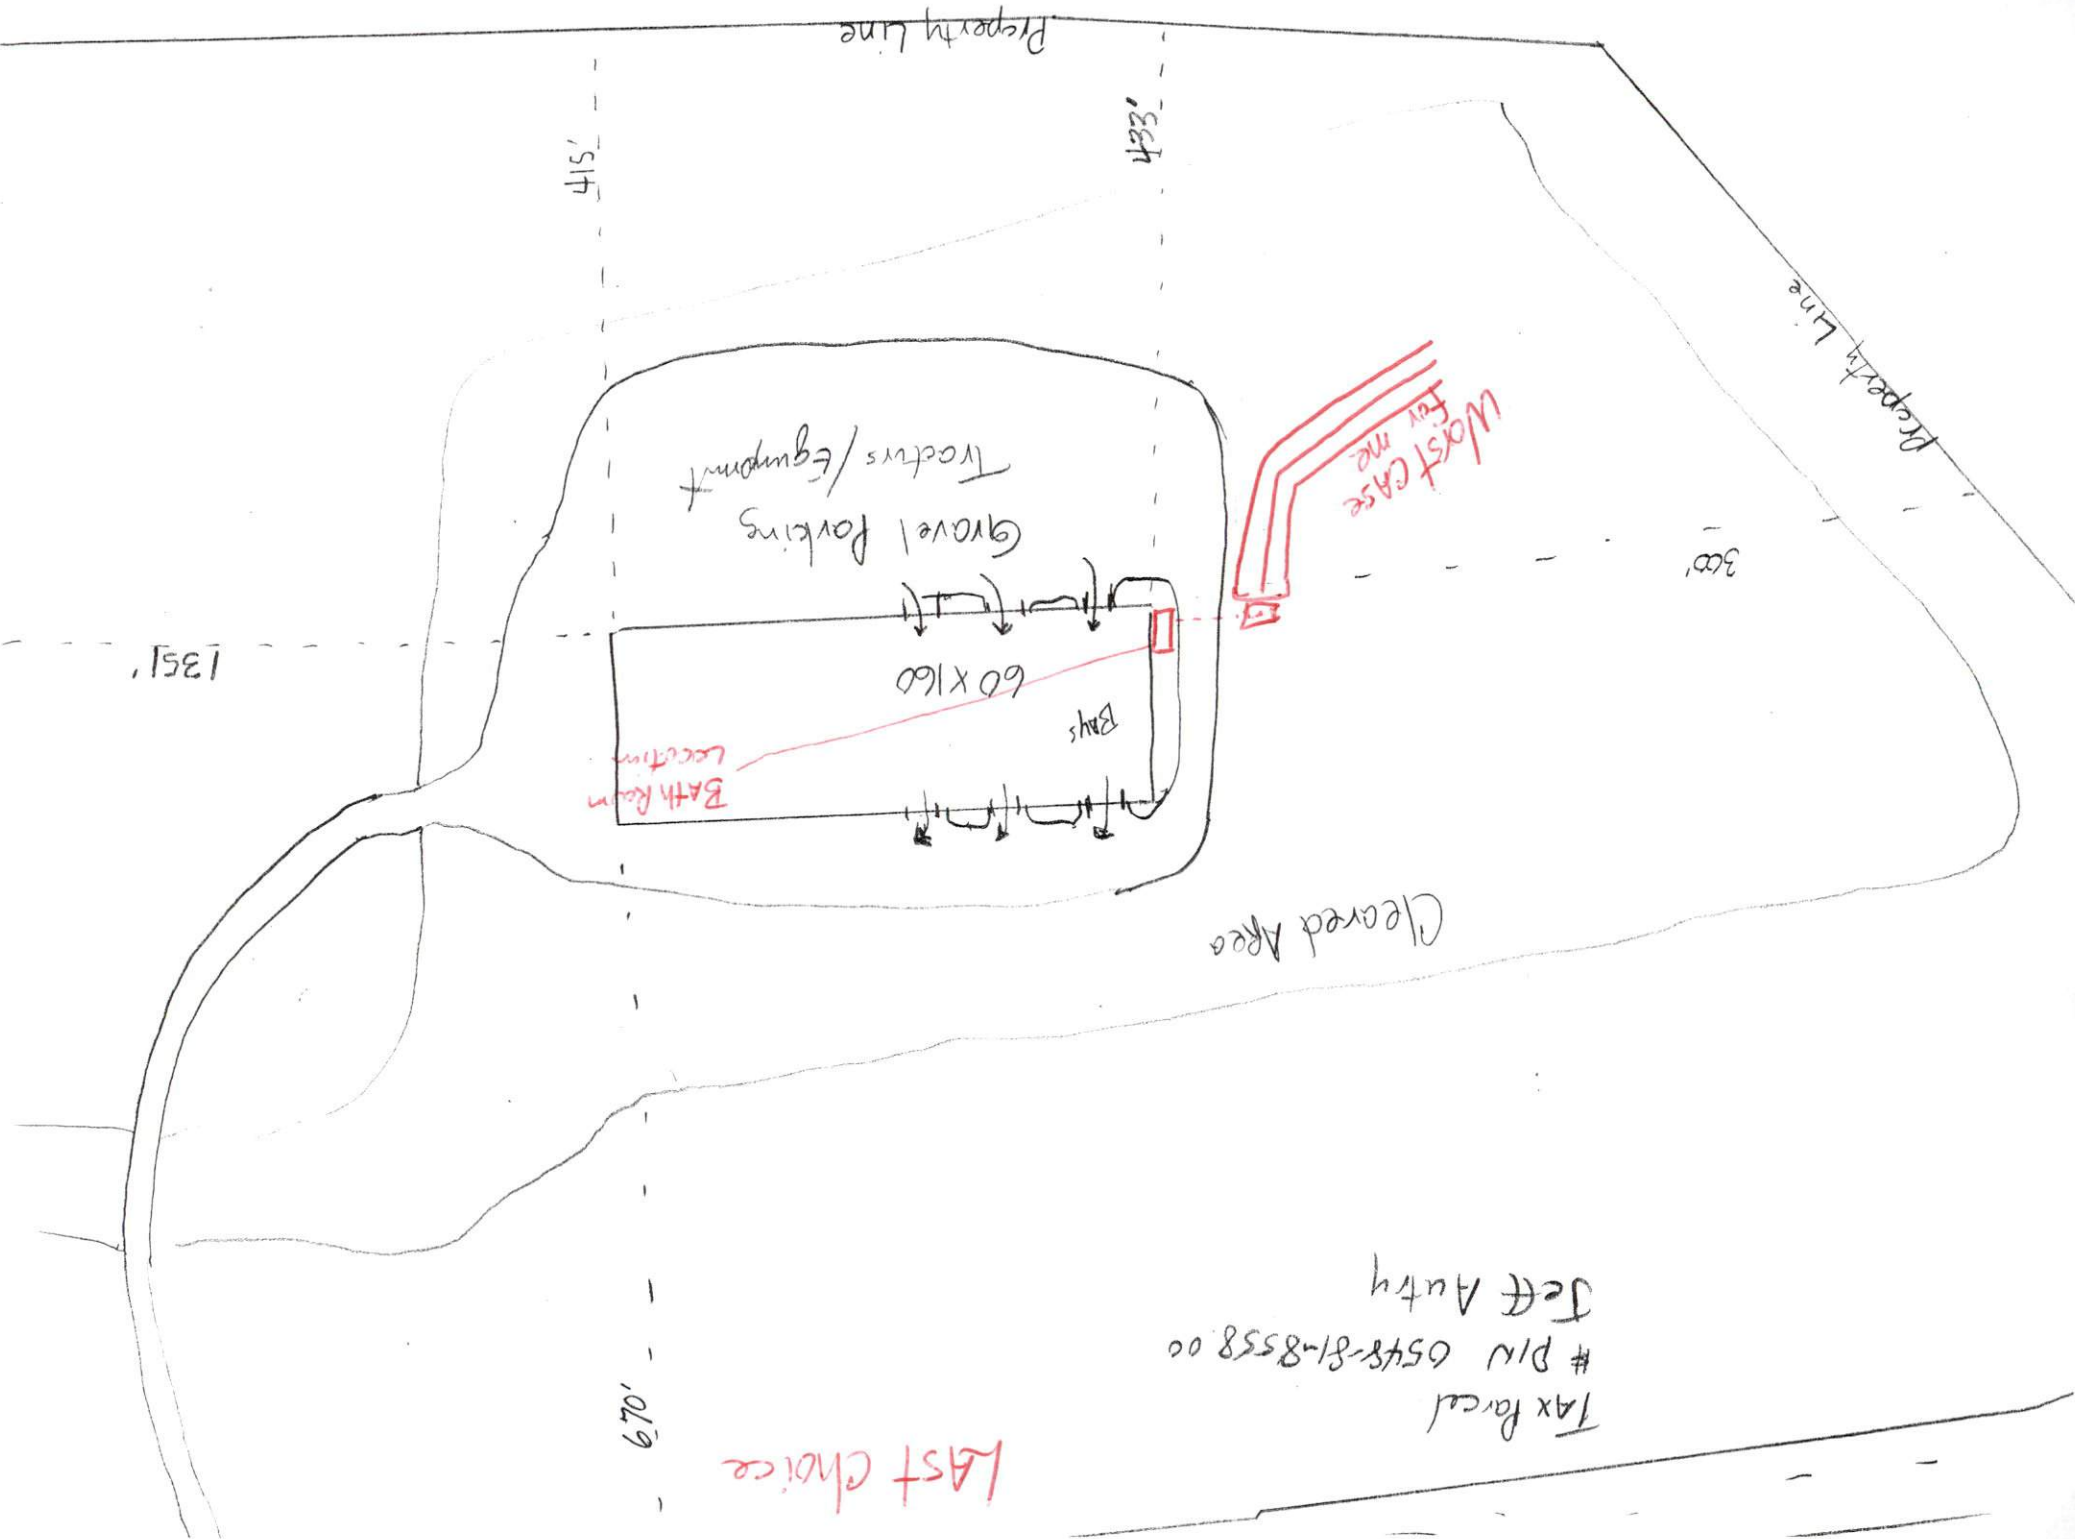
Show profile locations and other site features (dimensions, references or benchmark, and North)
